ALDWICK BAY ESTATE

"Tradewinds" 7 Arun Way, Aldwick Bay Estate.

AW/228/17/HH "Demolition of water tank and garden room and erection of detached garage"

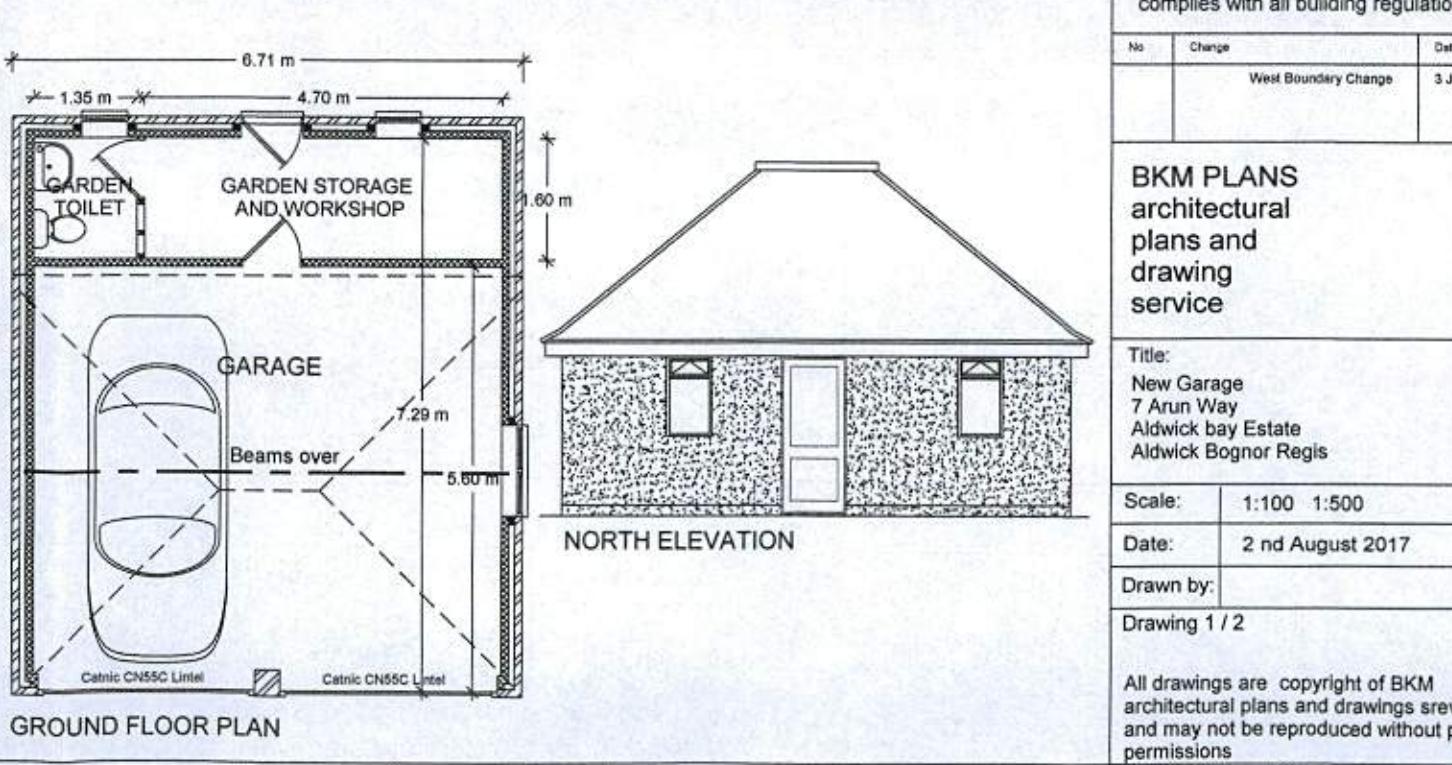
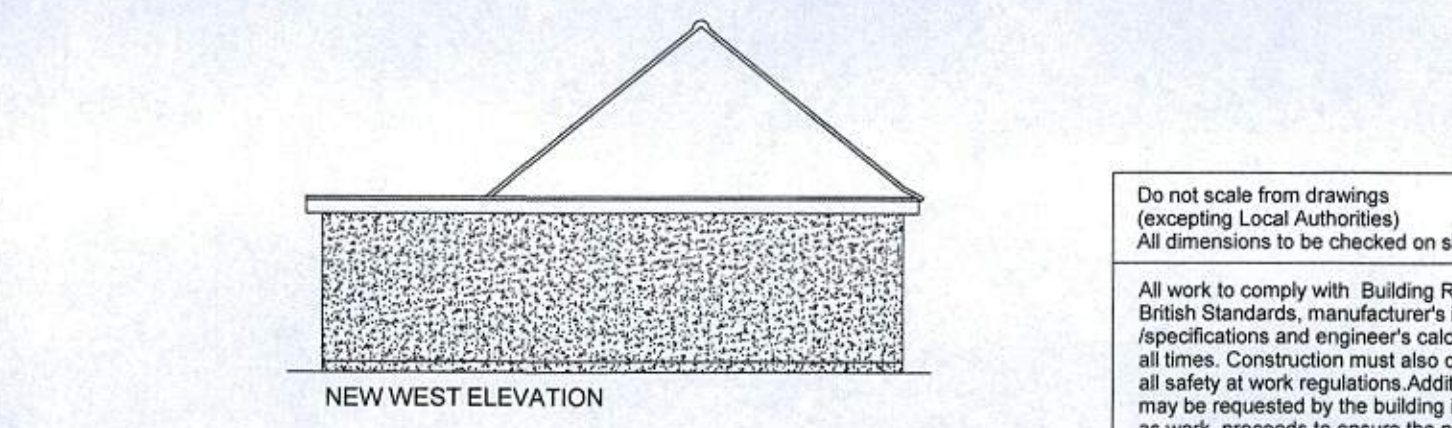
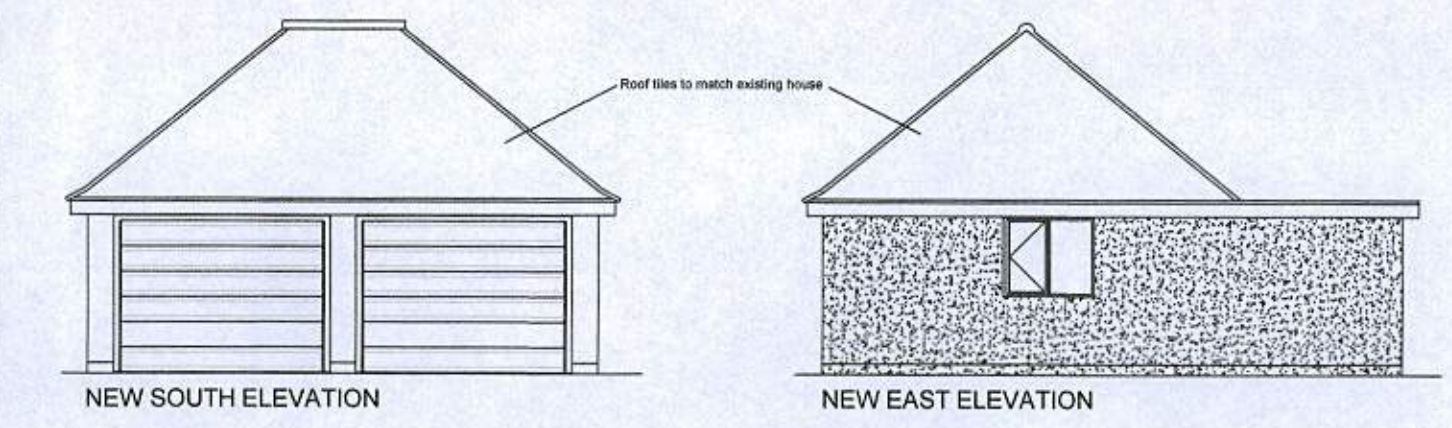
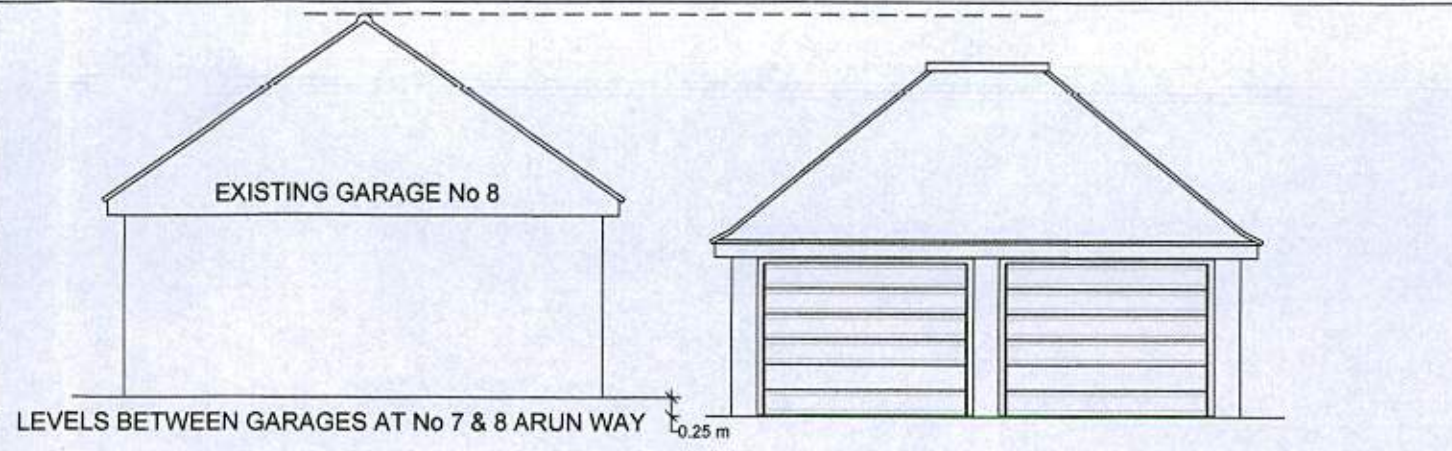
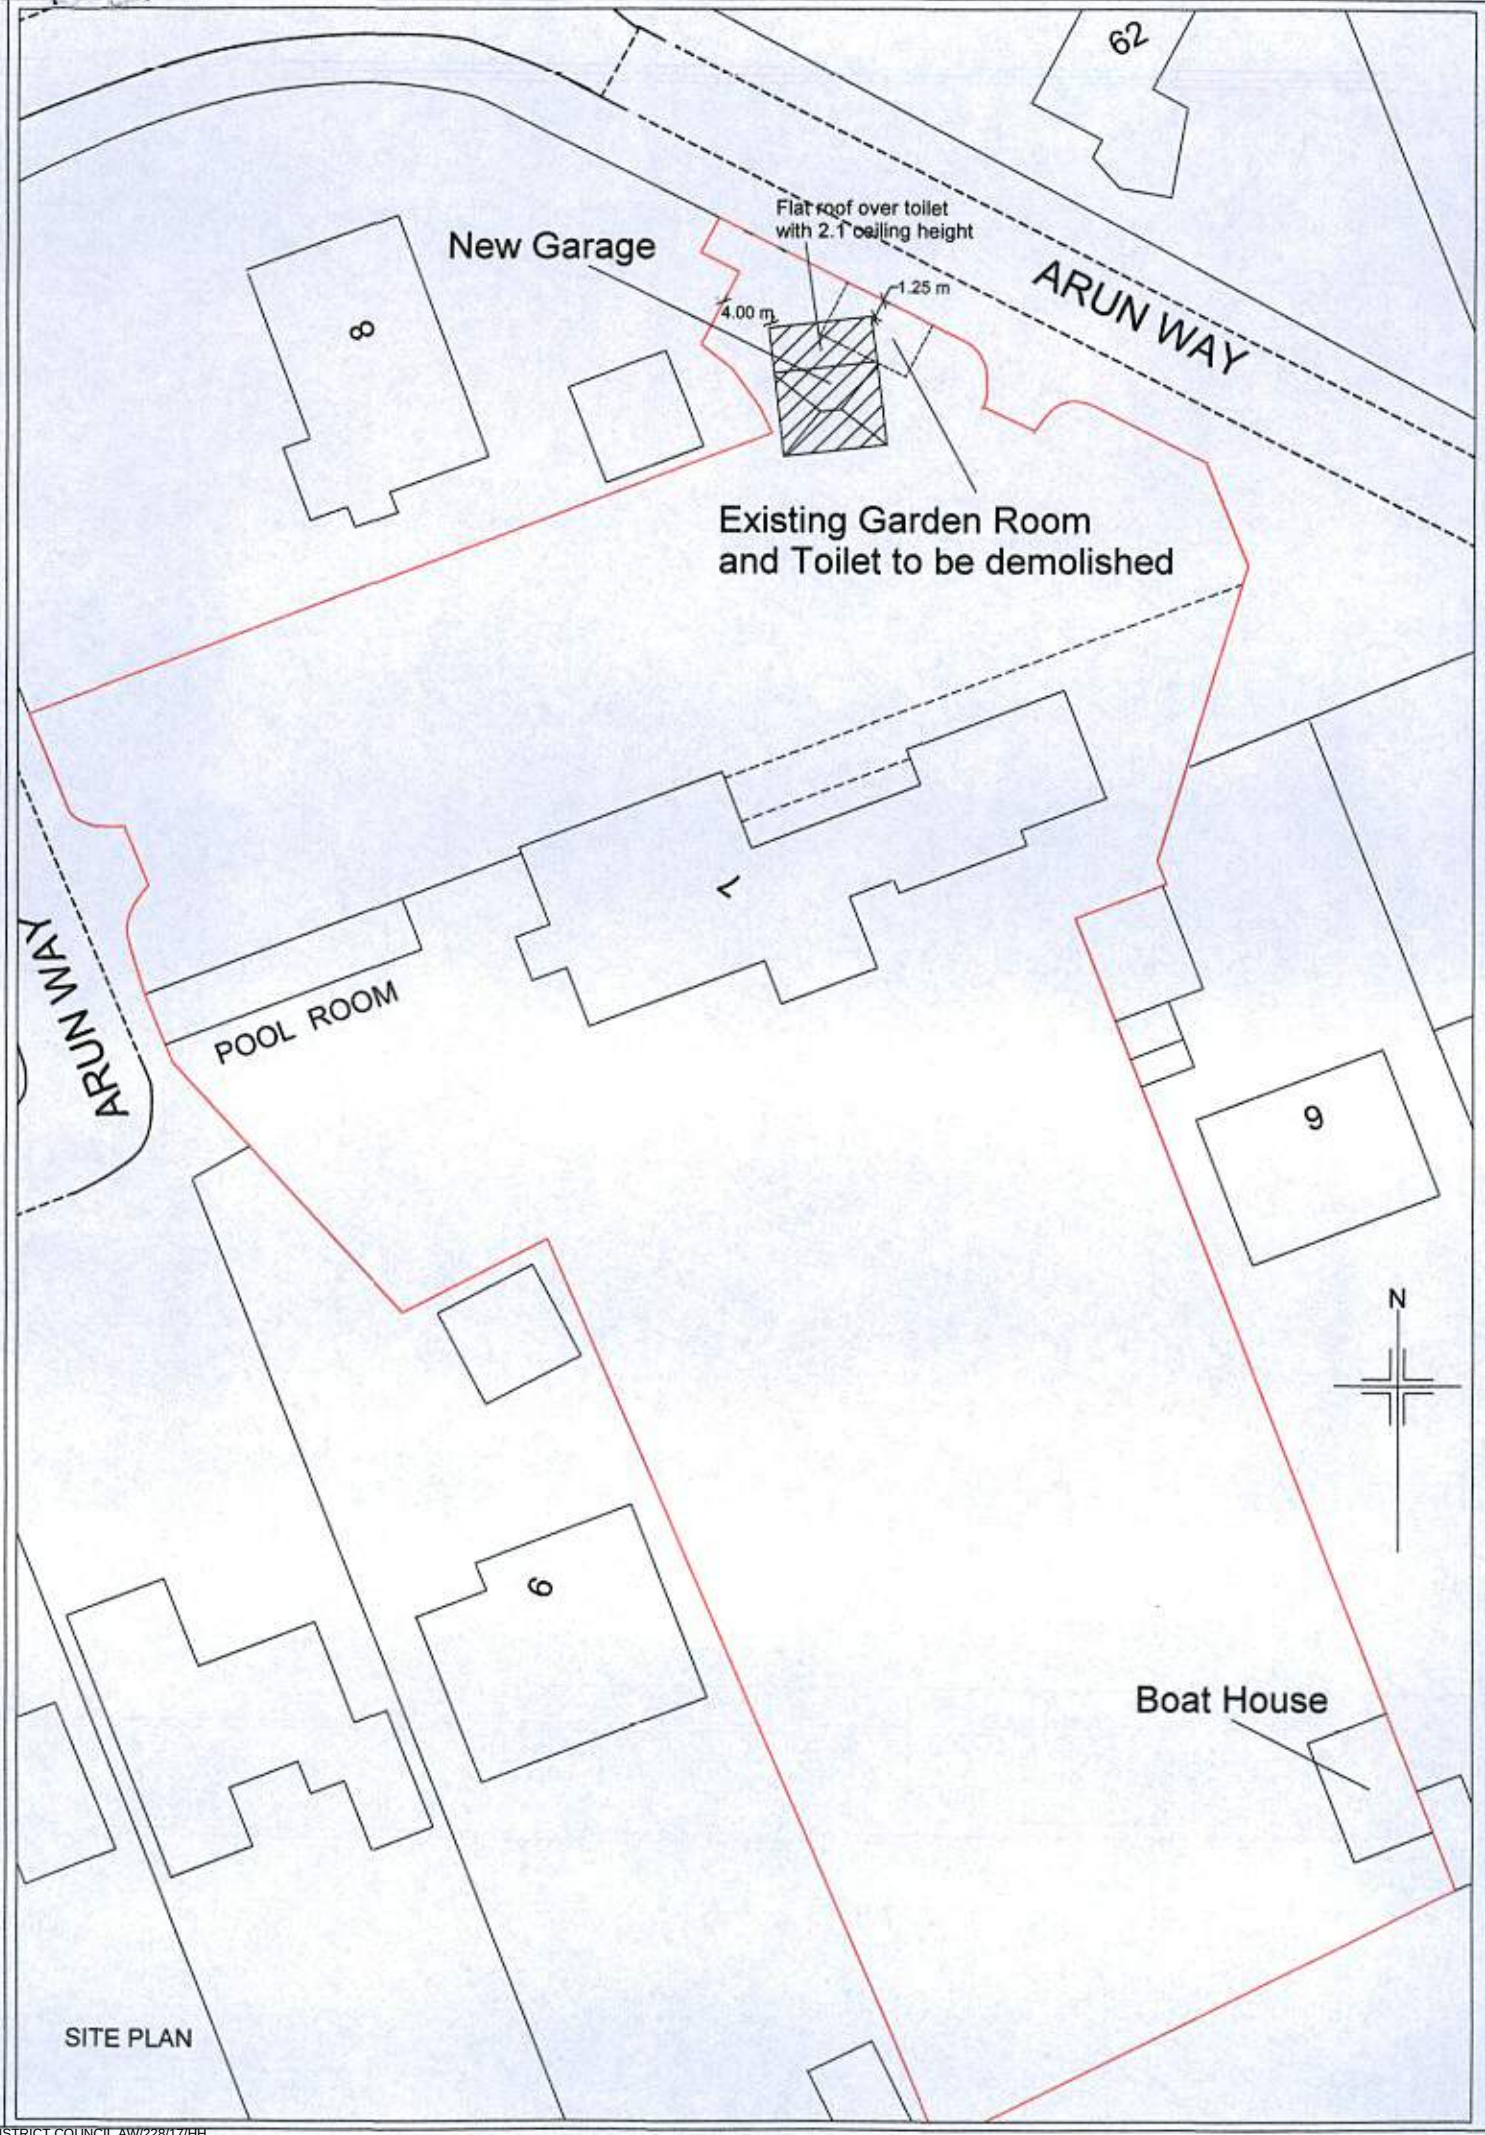
1. We have no objection to the design and size of the proposal, provided the materials used and the detailing carefully match those of the original house.
2. The garage will not now or at any time in the future be used as a separate accommodation unit.
